Re: Marist Catholic College North Shore (SSD-10473)
Response to Submissions

We refer to the response provided by DPIE to the State Significant Development Application for Marist Catholic Collage North Shore and specifically the comments on the landscape design and provide our response as follows.

The Landscape Drawings prepared by Oculus dated 01/02/21 are generally considered acceptable subject to the following amendments:

L - 106

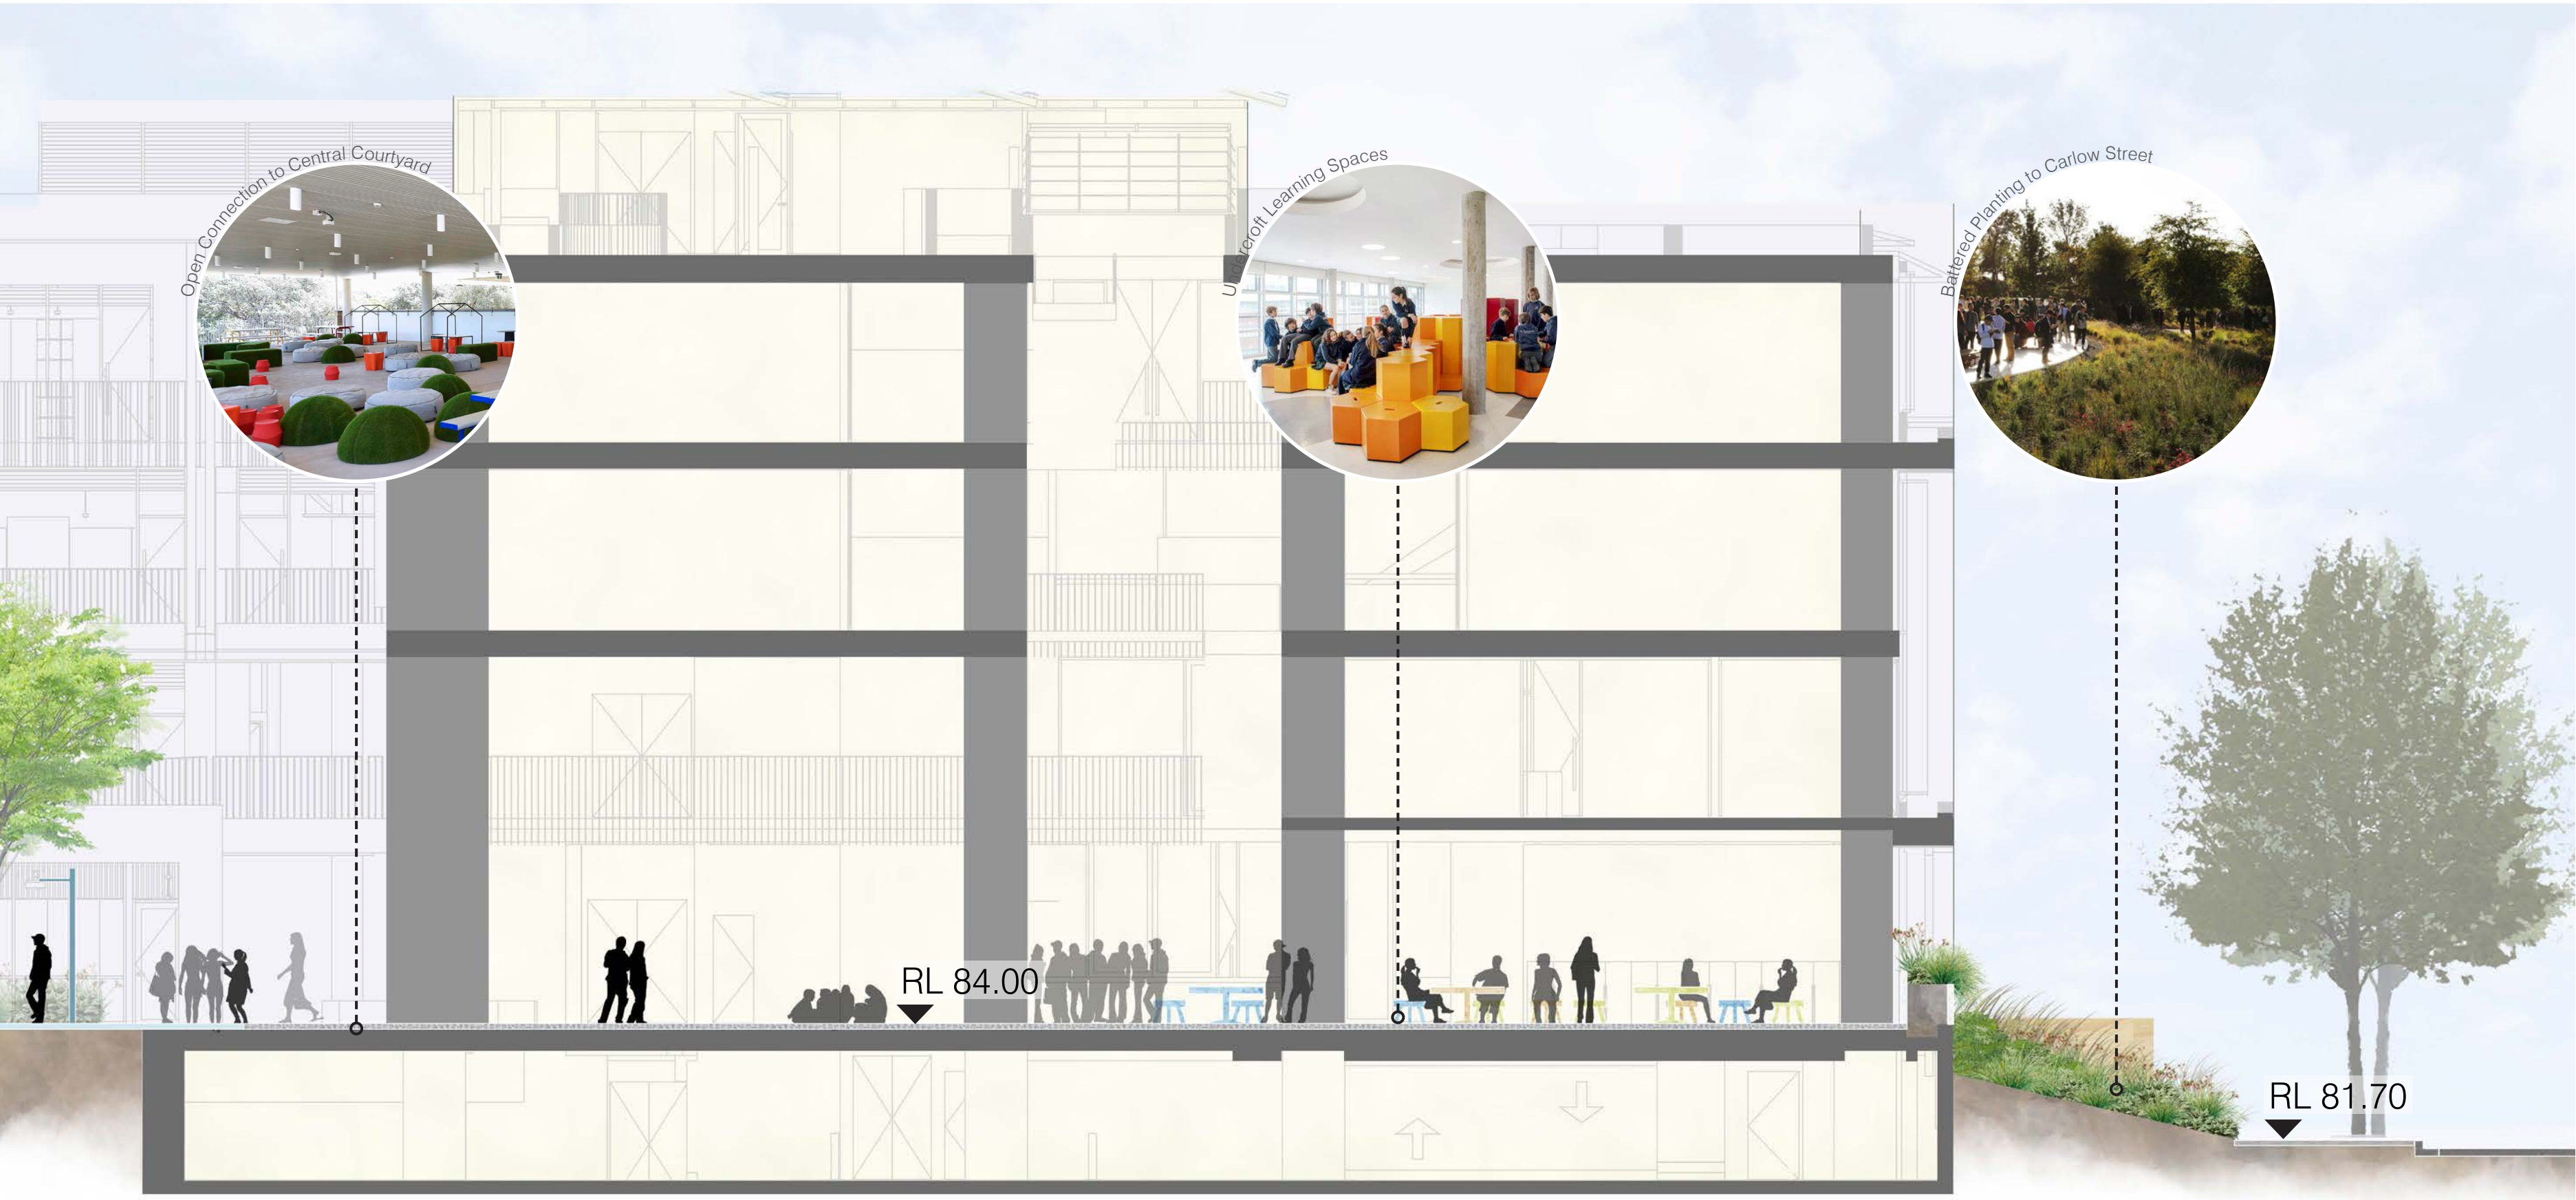
Further consideration should be given to the potential to provide natural screening for the site in order to reduce the bulk and scale of the proposed building. This may require consideration of street tree planting, if there is not sufficient space within the site.

Response: Landscape setbacks have been provided along Miller and particularly Carlow Streets. Planting plans have been provided as part of this Response to Submissions to show the specific species to be provided in each area (refer drawings L07 & L08). As part of this Response to Submissions, additional tree planting has been proposed for the Carlow St setback in addition to the existing Tallowwood tree TQ97 which is being retained. The landscape setback to Carlow Street will be graded up towards the building (apart from around the existing tree) to reduce the extent of blank wall at the base of the building noting that the ground floor level is higher than the street. There are also planters proposed for along the elevated Carlow and Miller Street edges of the undercroft space. Refer to section B on L106 and A on L107.
